WALLARAH 2 COAL PROJECT
RESPONSE TO PLANNING ASSESSMENT COMMISSION REVIEW REPORT
for
Wyong Areas Coal Joint Venture

1 INTRODUCTION

The PAC report also identified some outstanding issues that needed to be resolved prior to determination by the consent authority. This report addresses the unresolved issues identified by the PAC.

Conceptual Tooheys Road Site Layout

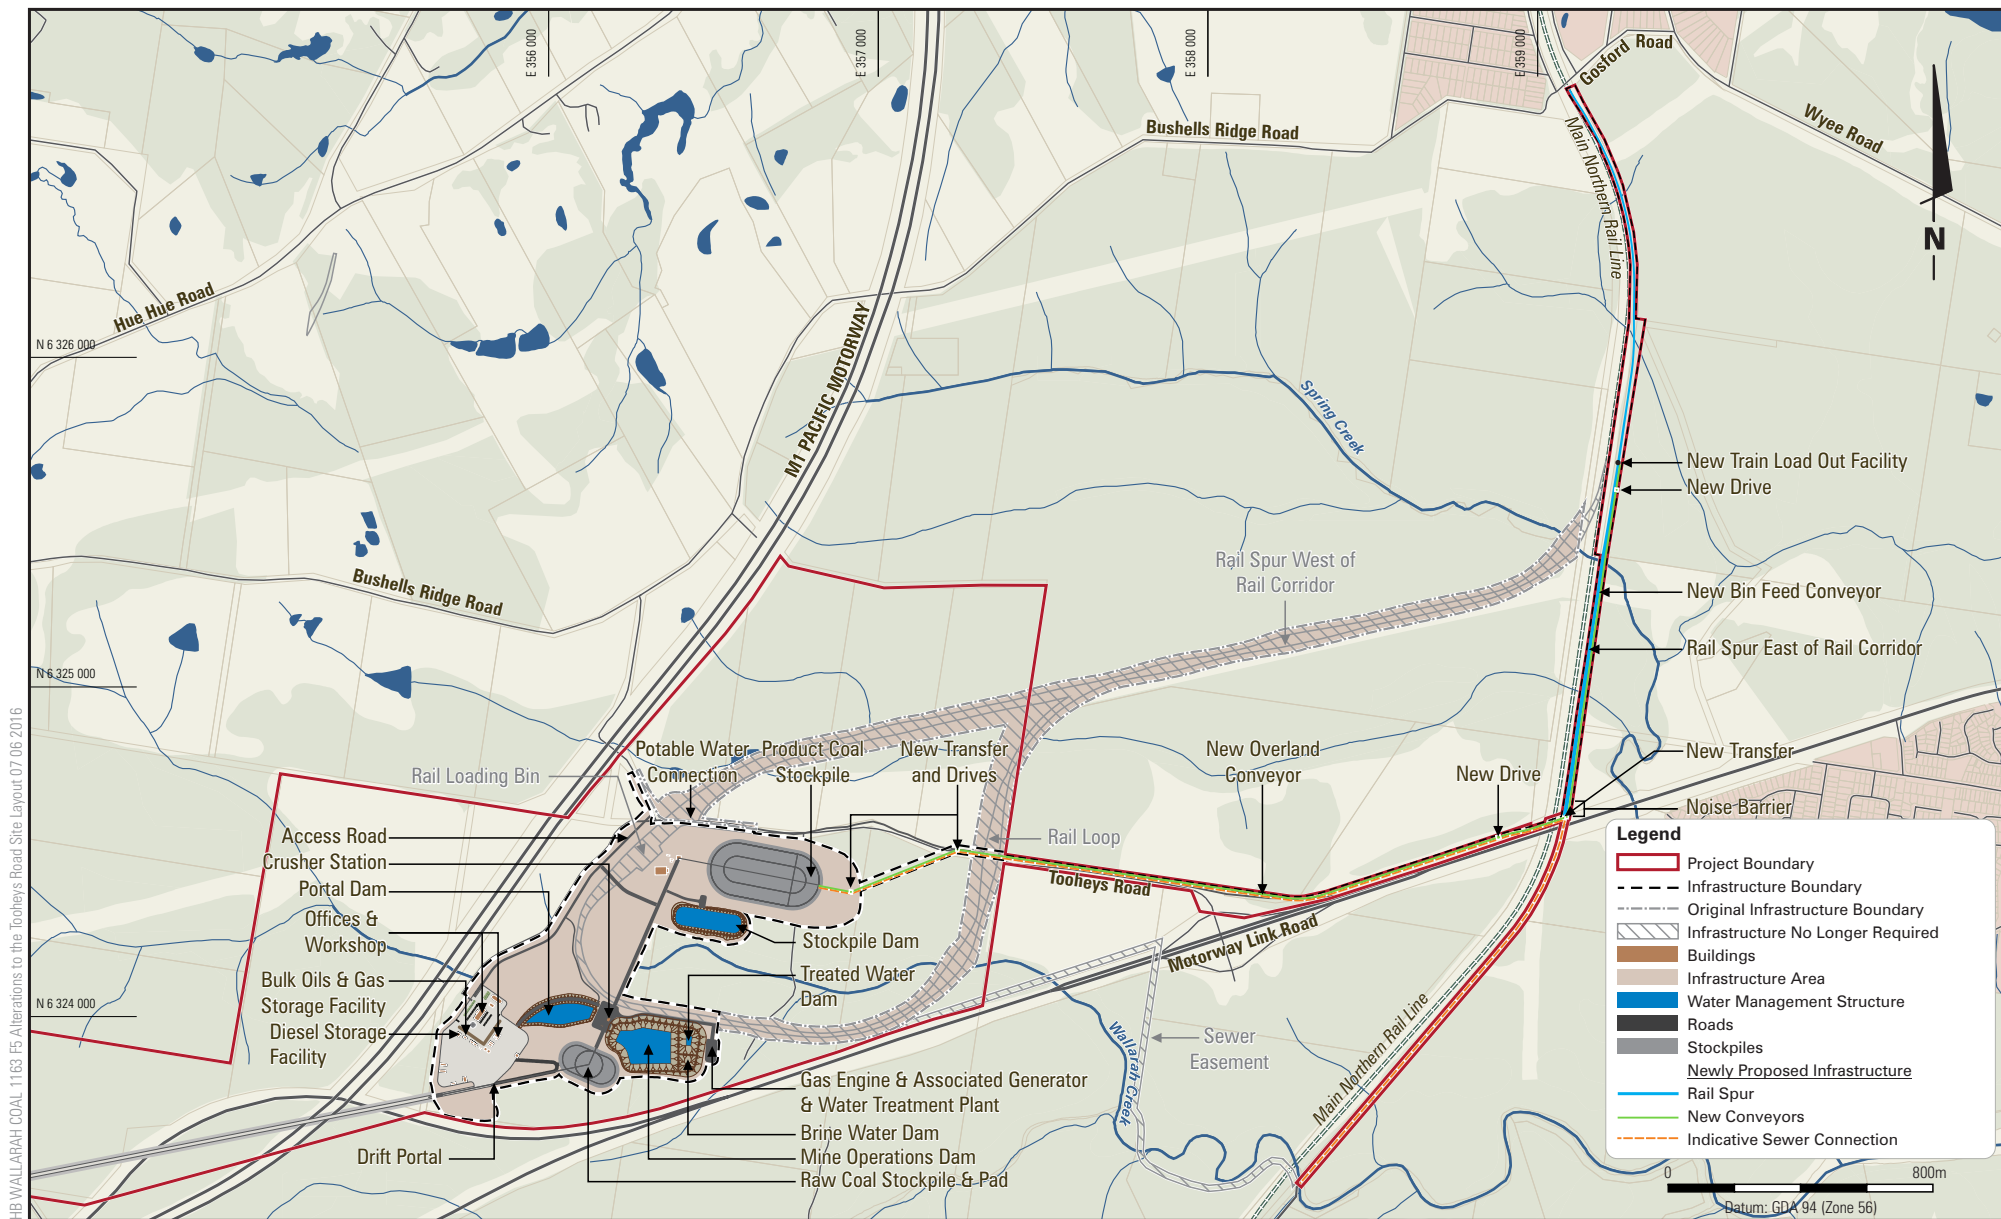
The PAC recommends monitoring of wheel squeal noise generated by trains on the rail loop. Transport for NSW has confirmed that 200 m is the minimum radius required to reduce wheel squeal noise.

The rail loop consists of four bends with radii of 500 m, 500 m, 200 m and 800 m. Therefore, the design of the rail loop complies with the minimum radii recommended by Transport for NSW.
